Planning & Urban Development Department

August 7, 2015

WARING PAUL &
529 BRIGHTON AVE
PORTLAND, ME 04102**CBL: 184 E003001**
Located at: 529 BRIGHTON AVE**Certified Mail 7010 1870 0002 8136 8909**

Inspection Violations

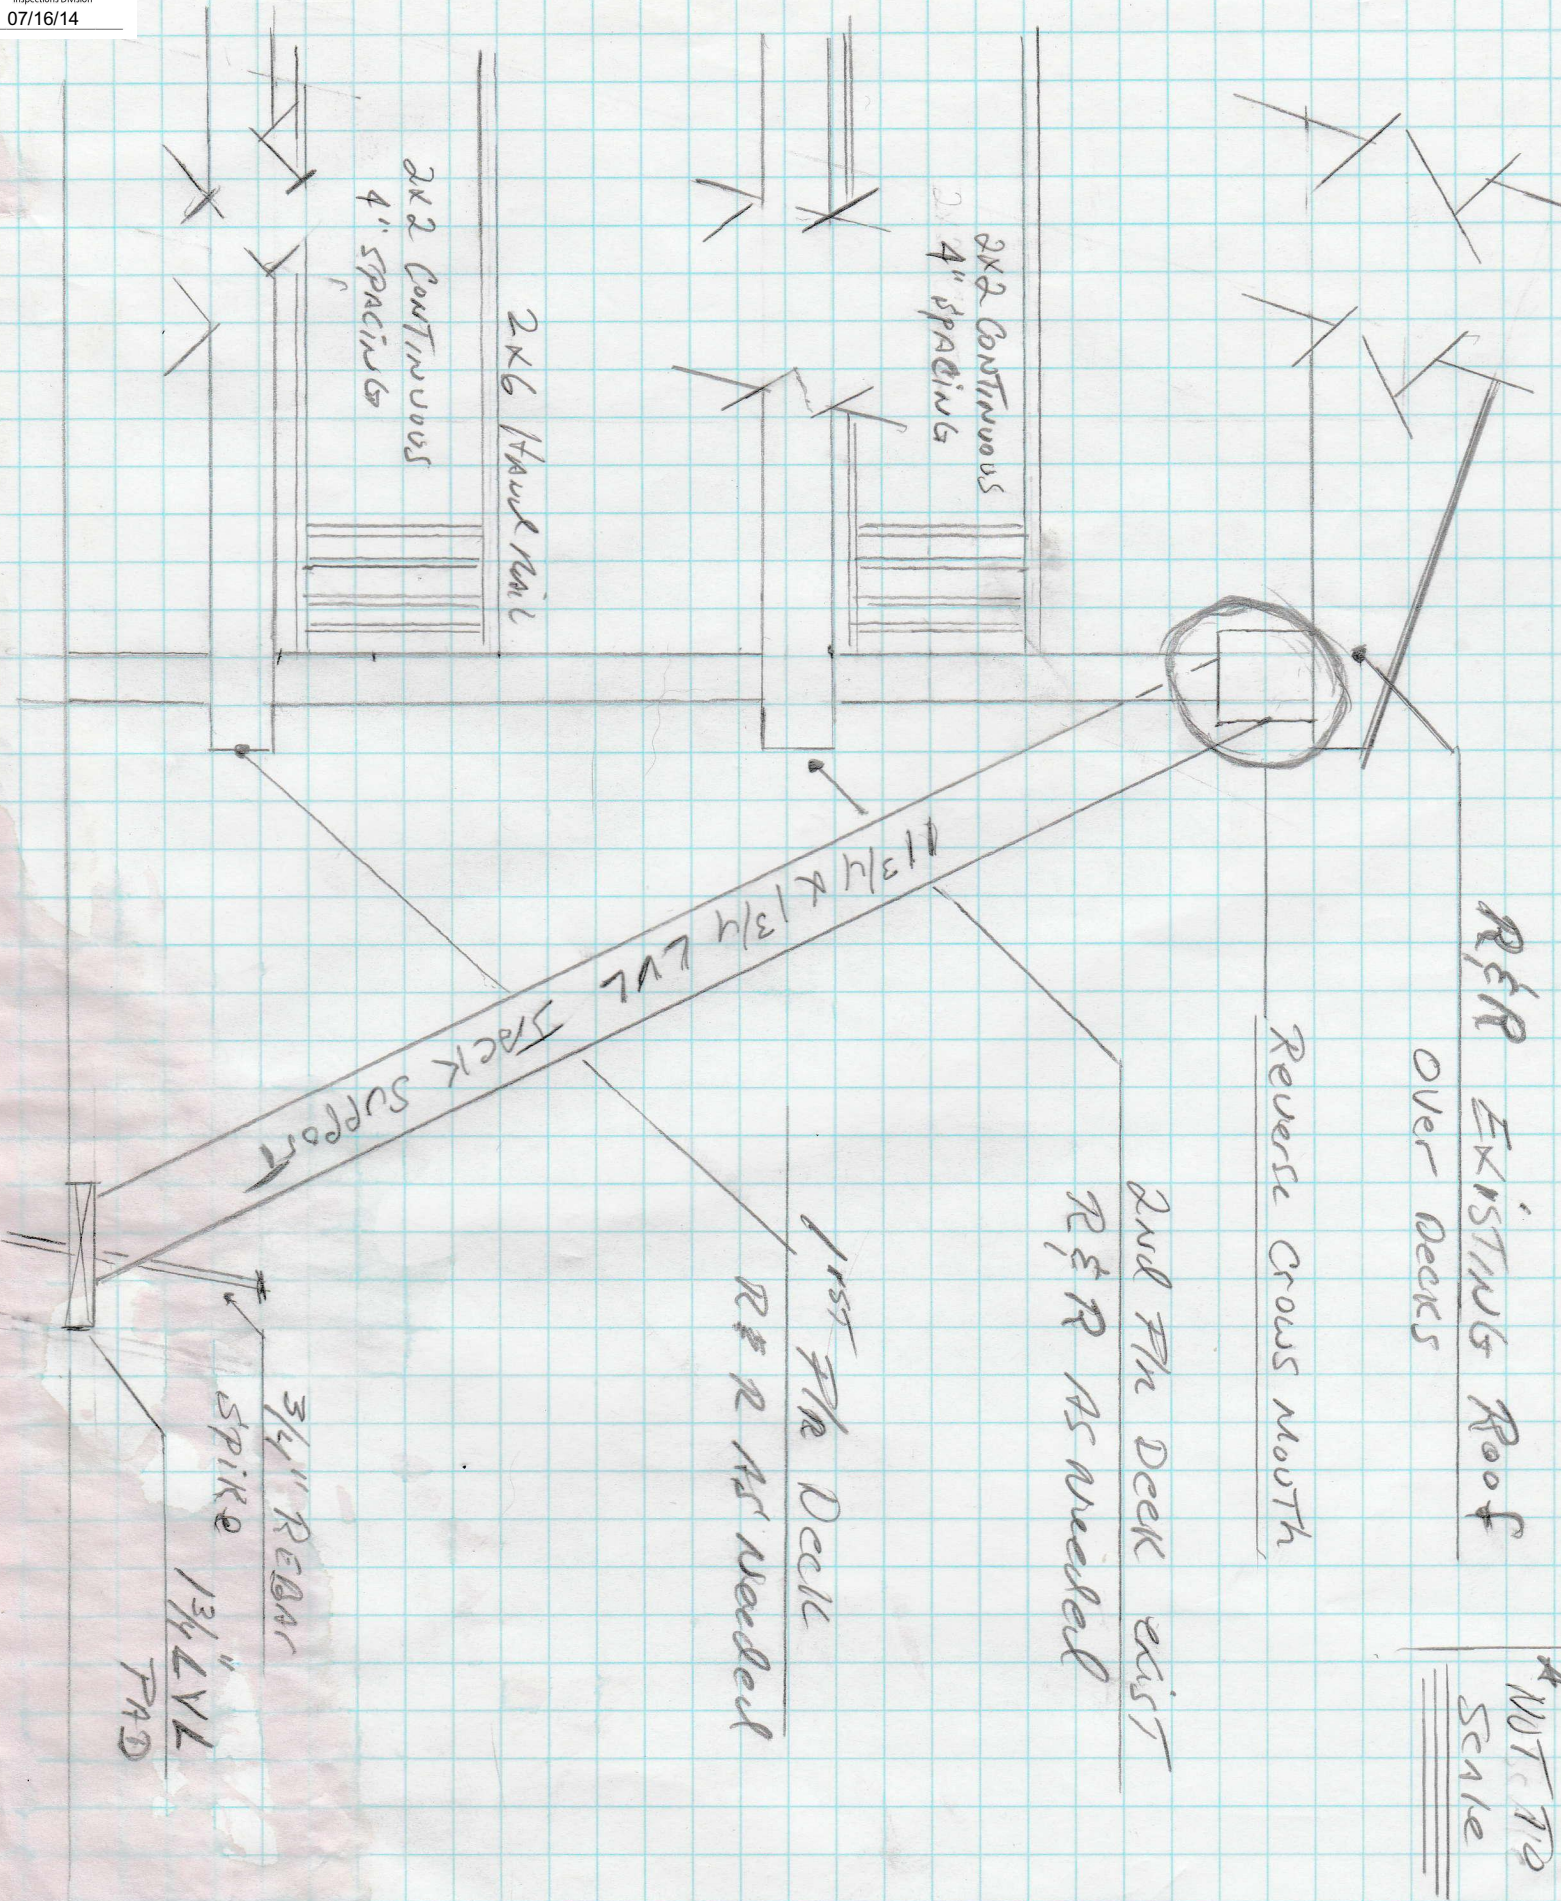
Notes: *The front deck needs repairs to ensure that the steps, decking and railings are all structurally sound*

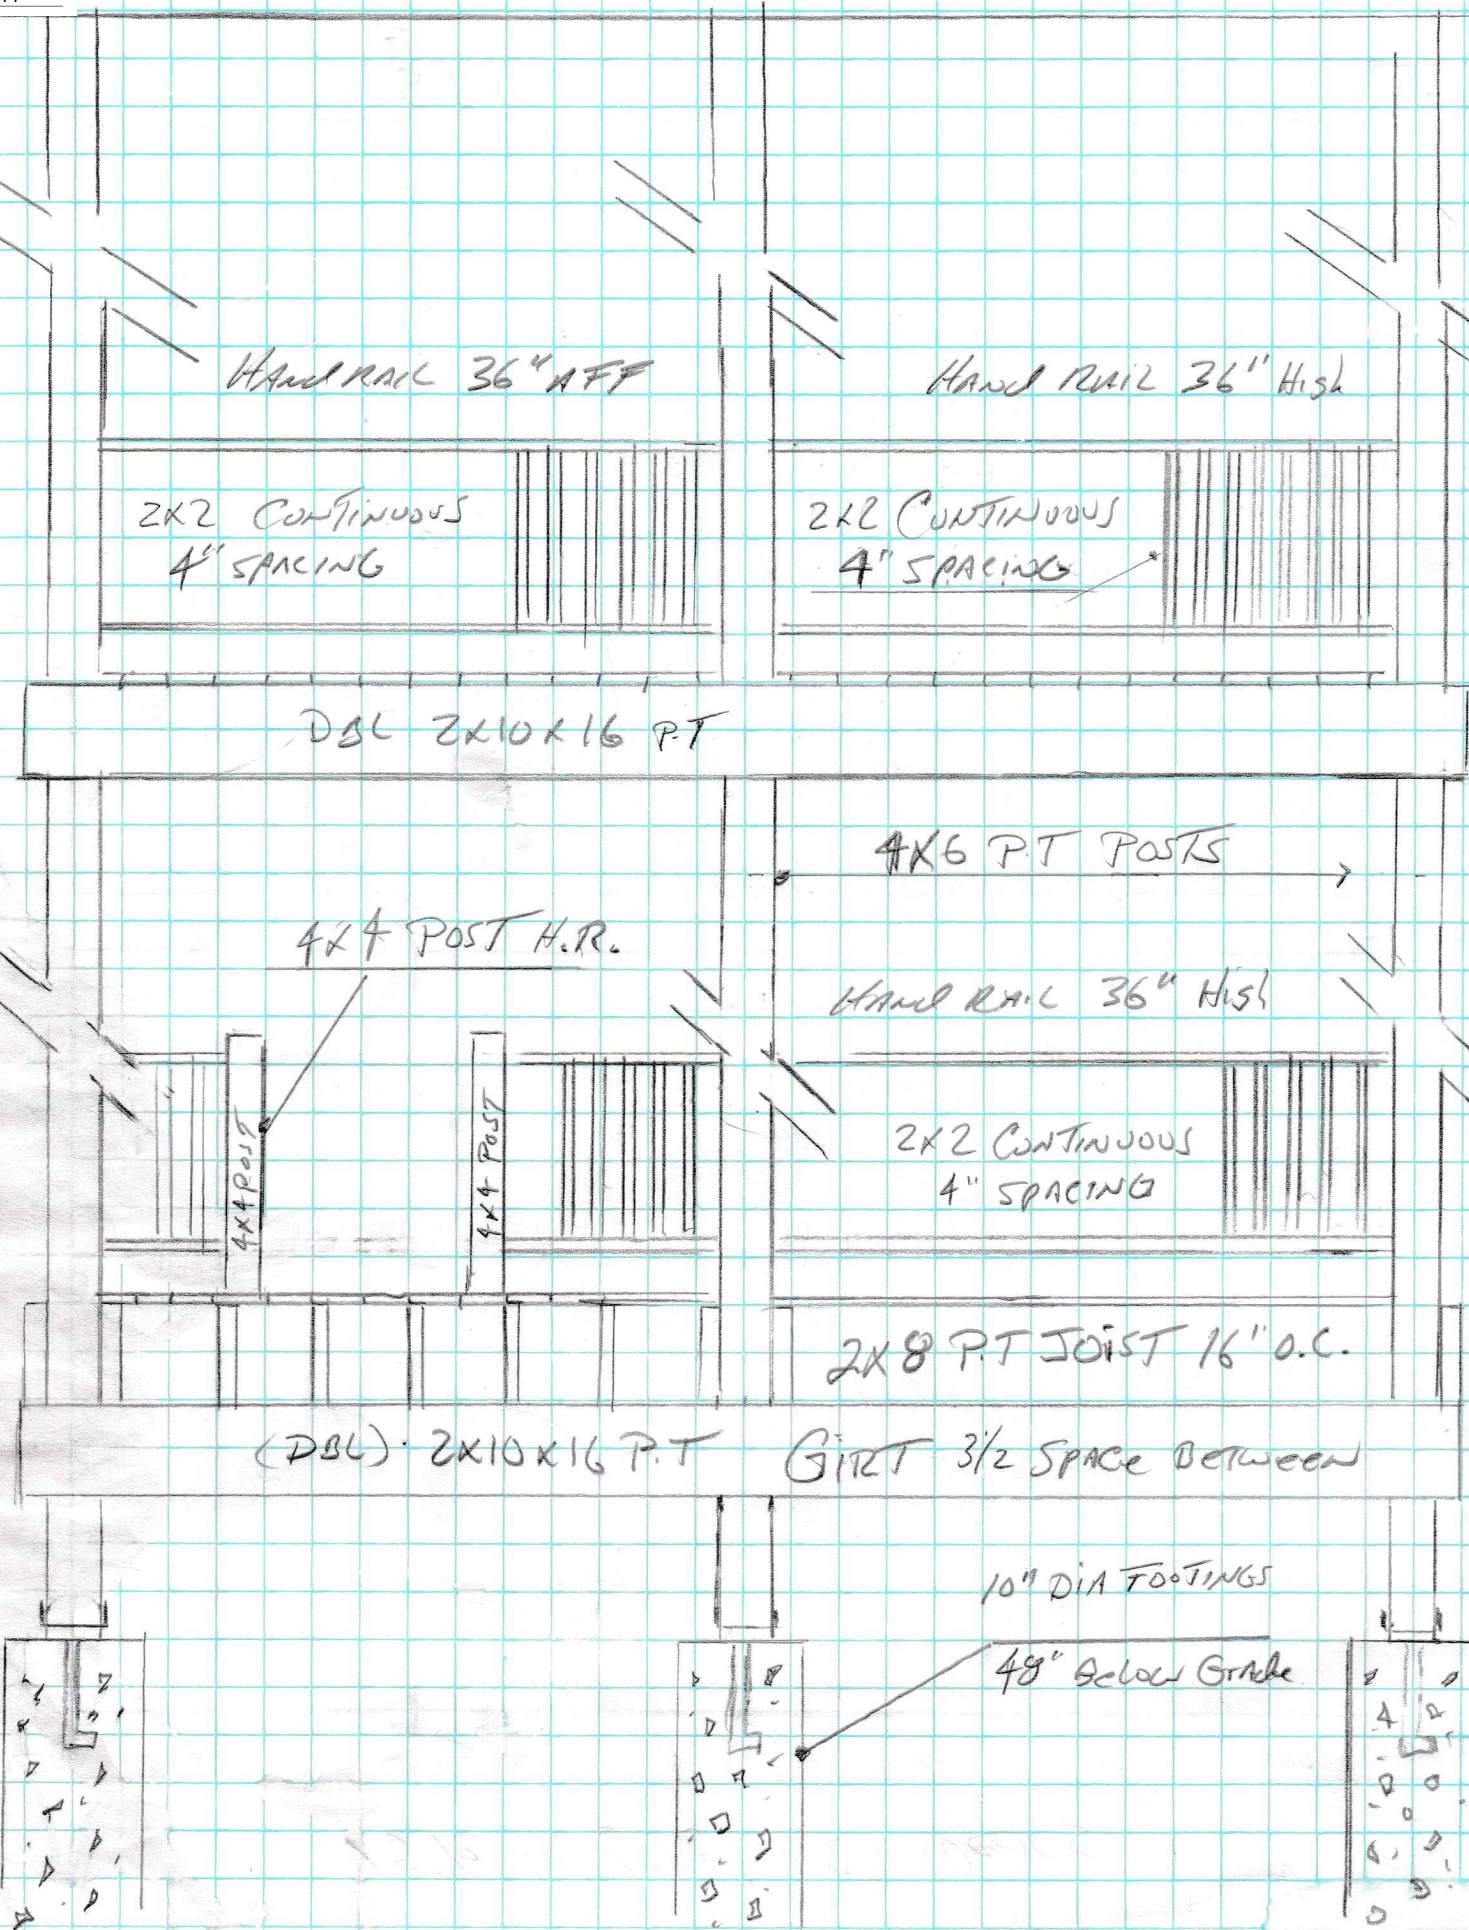
Comments: Deck appears to be unsafe, please develop a plan of action and inform this office within 30 days.
